DEVIATION REQUEST AND DECISION FORM

Project Name :	The Gardens at North Carefree
Schedule No.(s) :	5500000135
Legal Description :	See attached

A deviation from the standards of or in Section **Chapter 2, Section 2.2.4 B** of the Engineering Criteria Manual (ECM) is requested.

ECM Standard Drawing SD_2-3: Urban Non-Residential Collector Roadway.

SHEET 14 OF 34

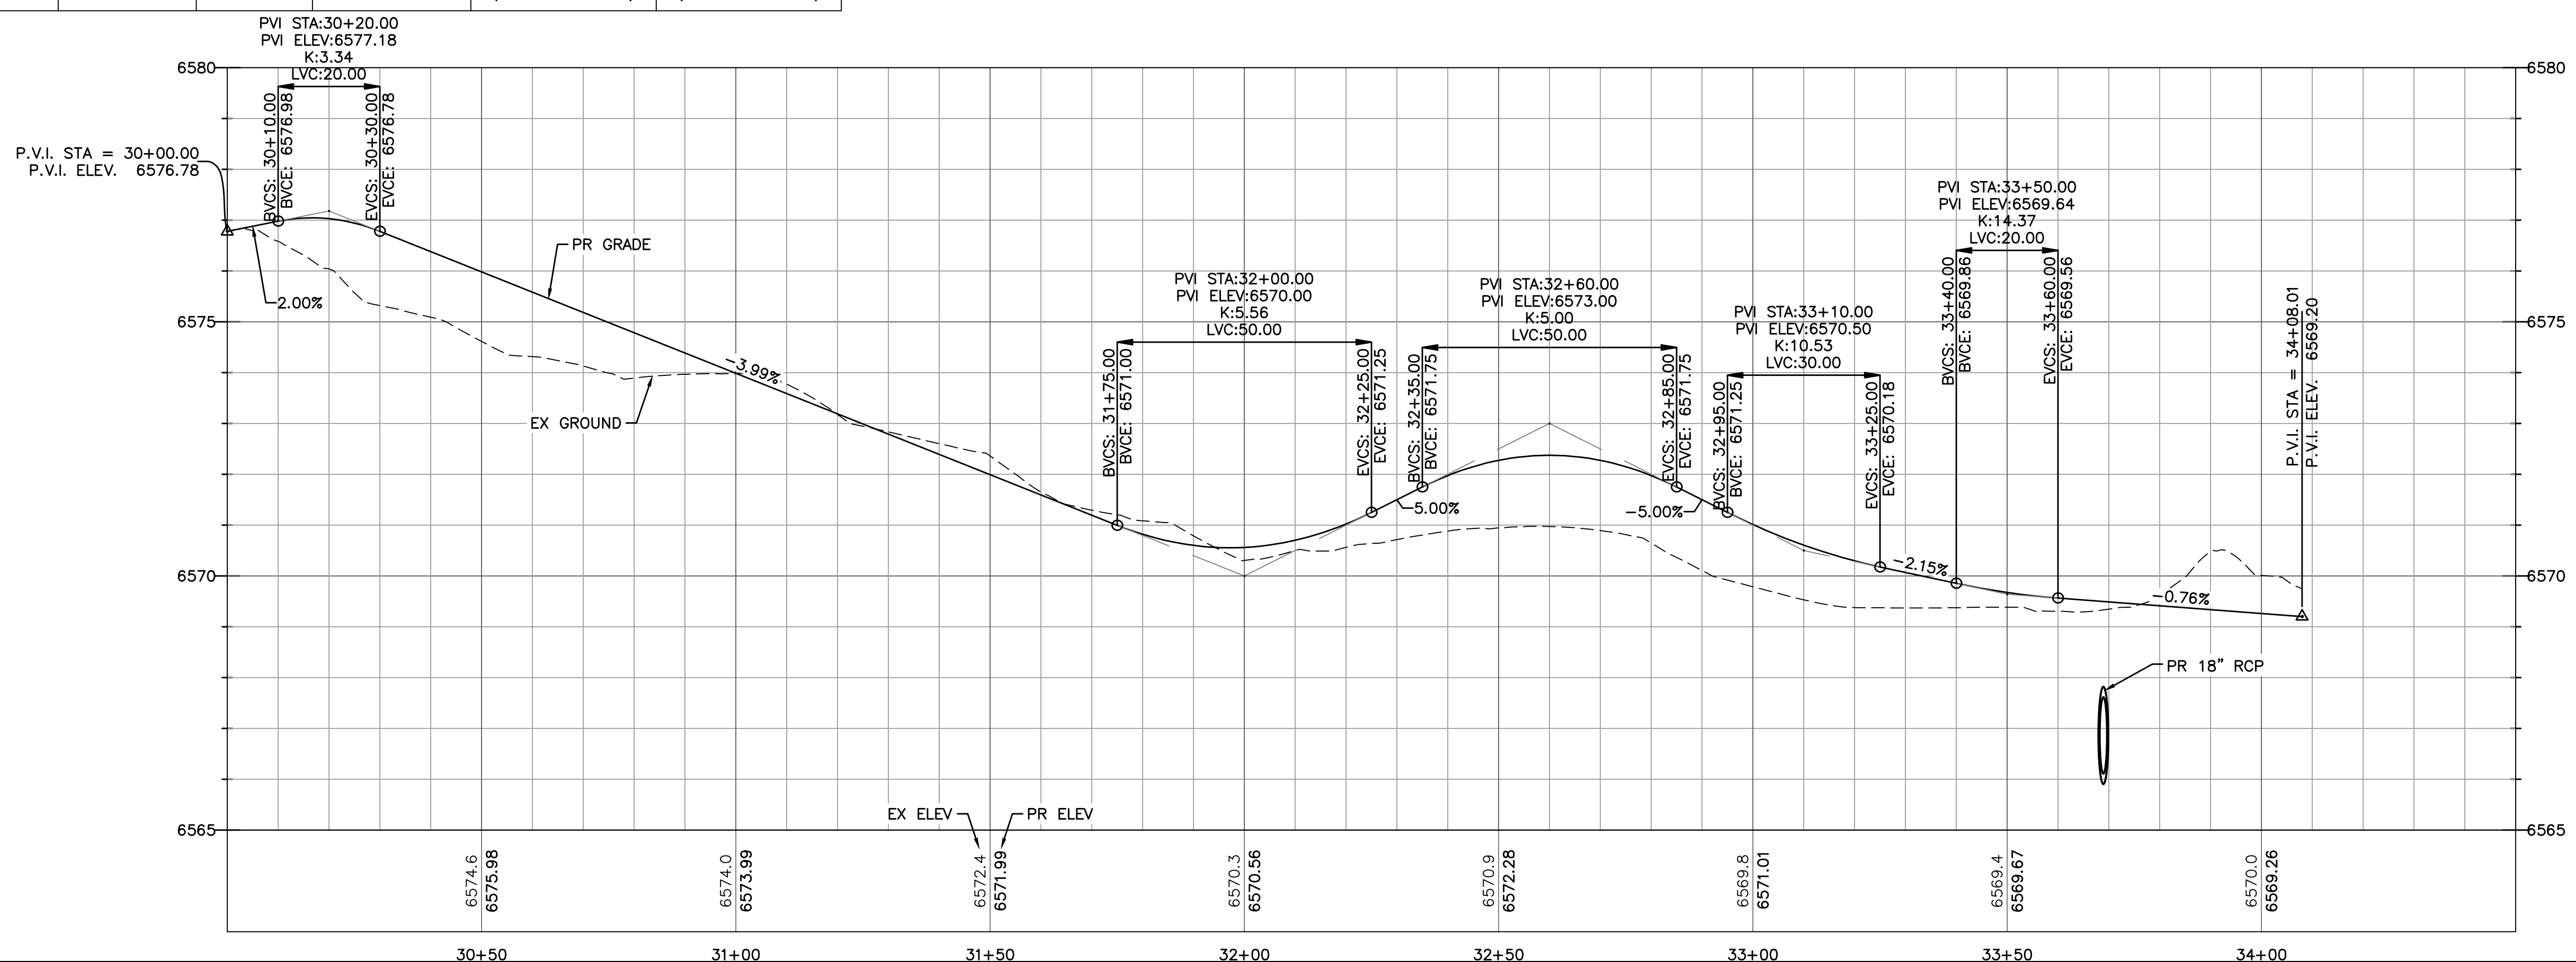
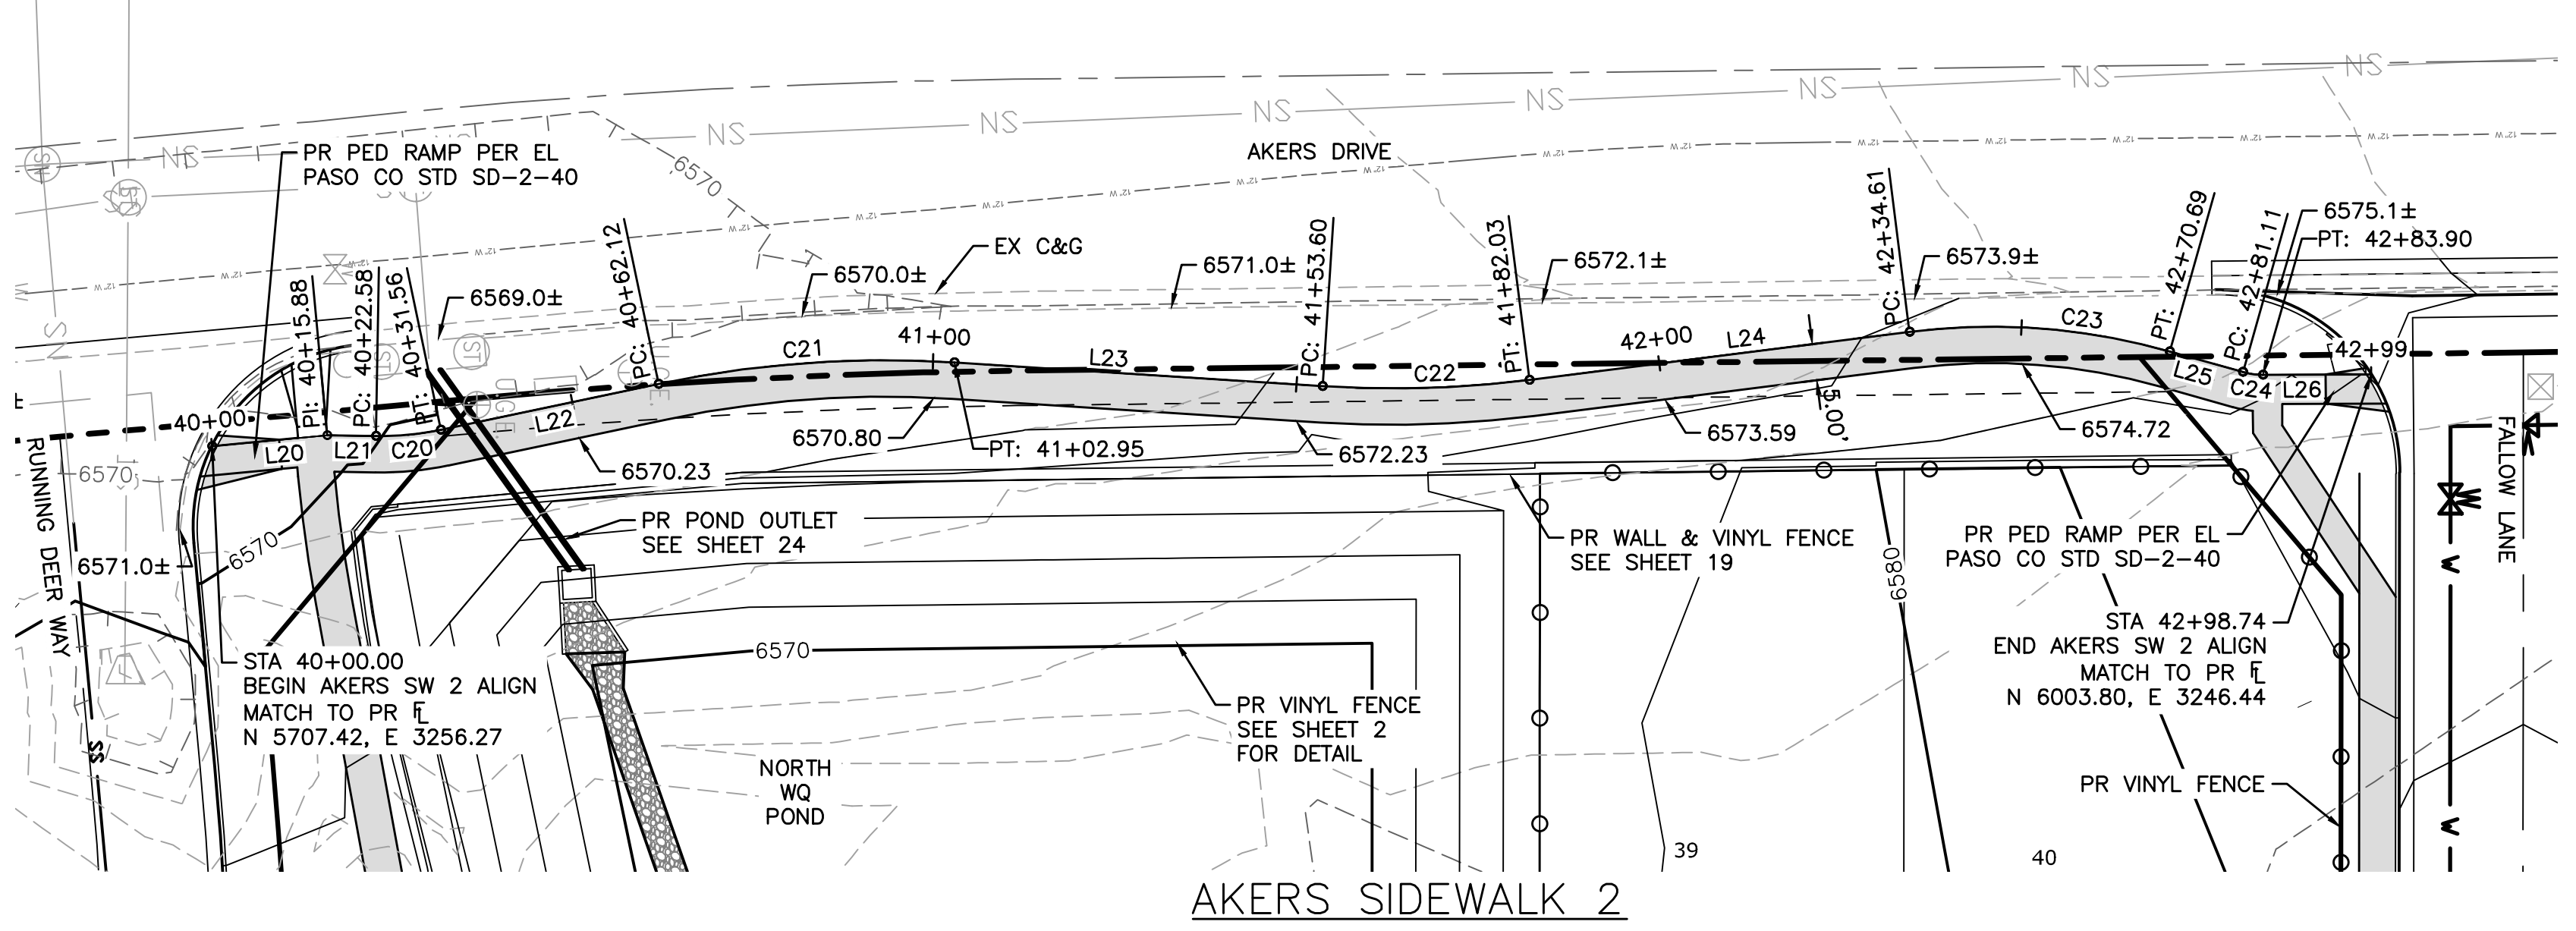
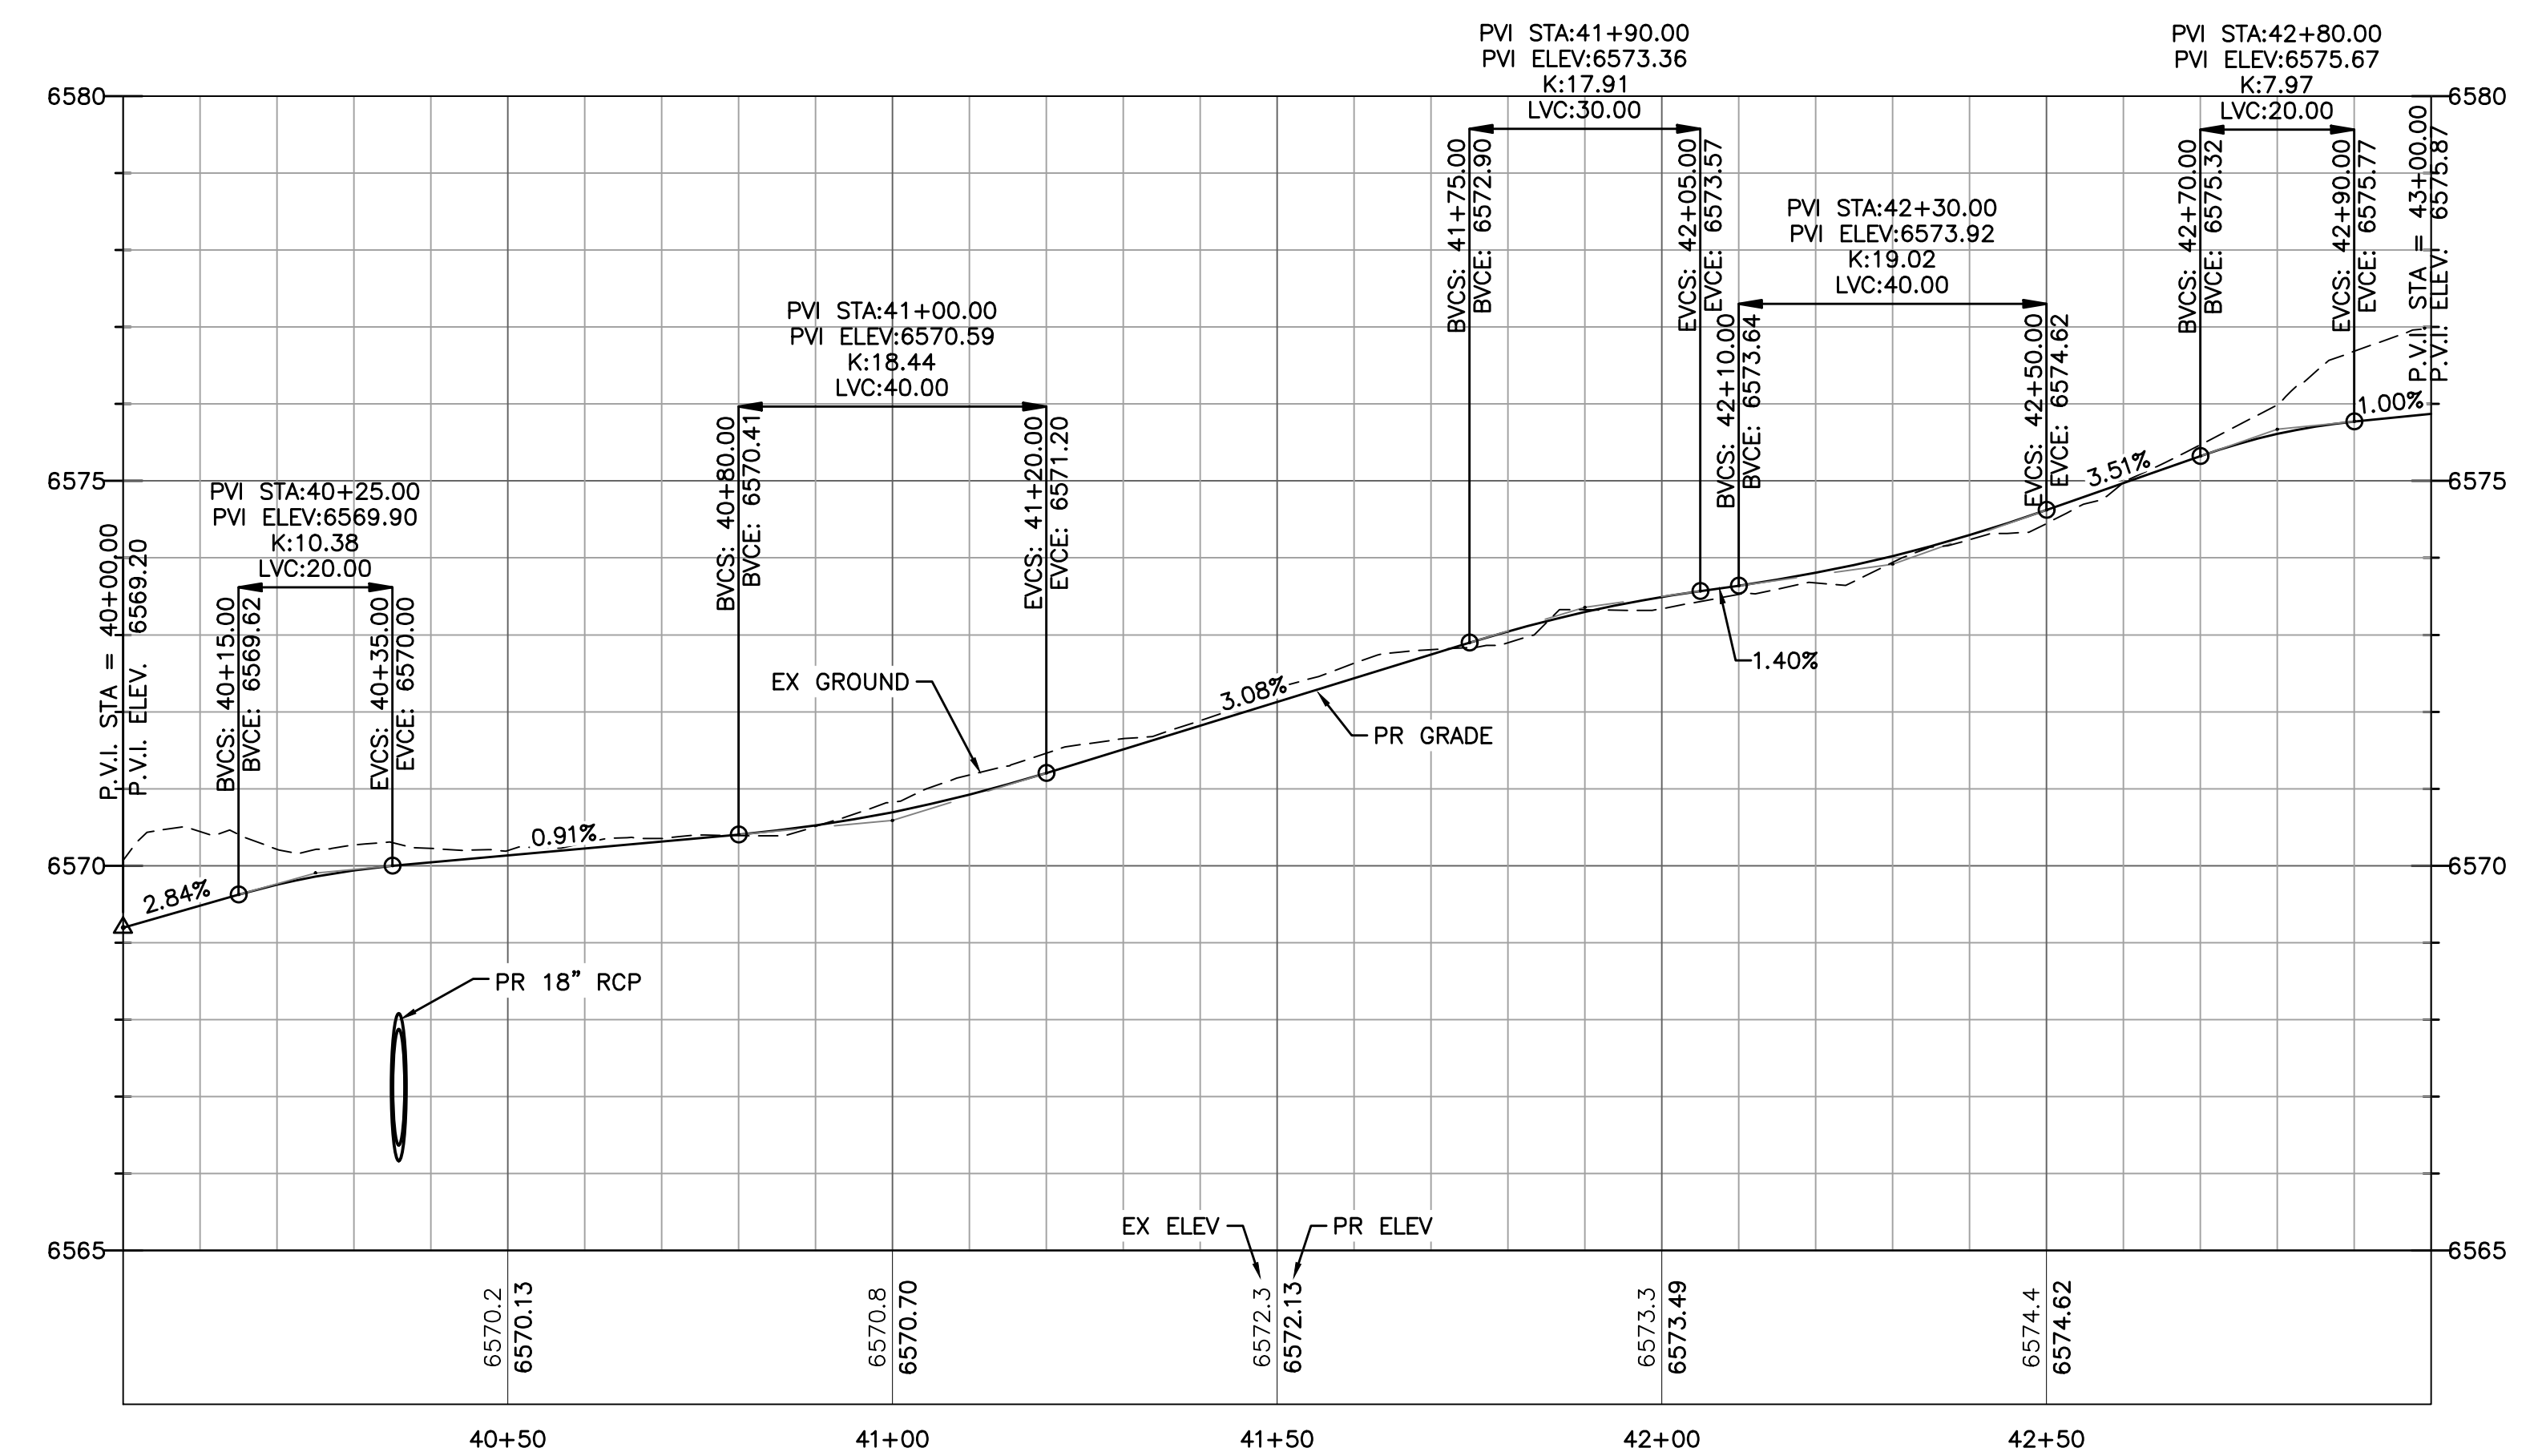
please provide an exhibit of the meandering sidewalk

There are portions of this sidewalk that are next to the curb and do not have this additional safe area behind the curb. Please update your justification accordingly.
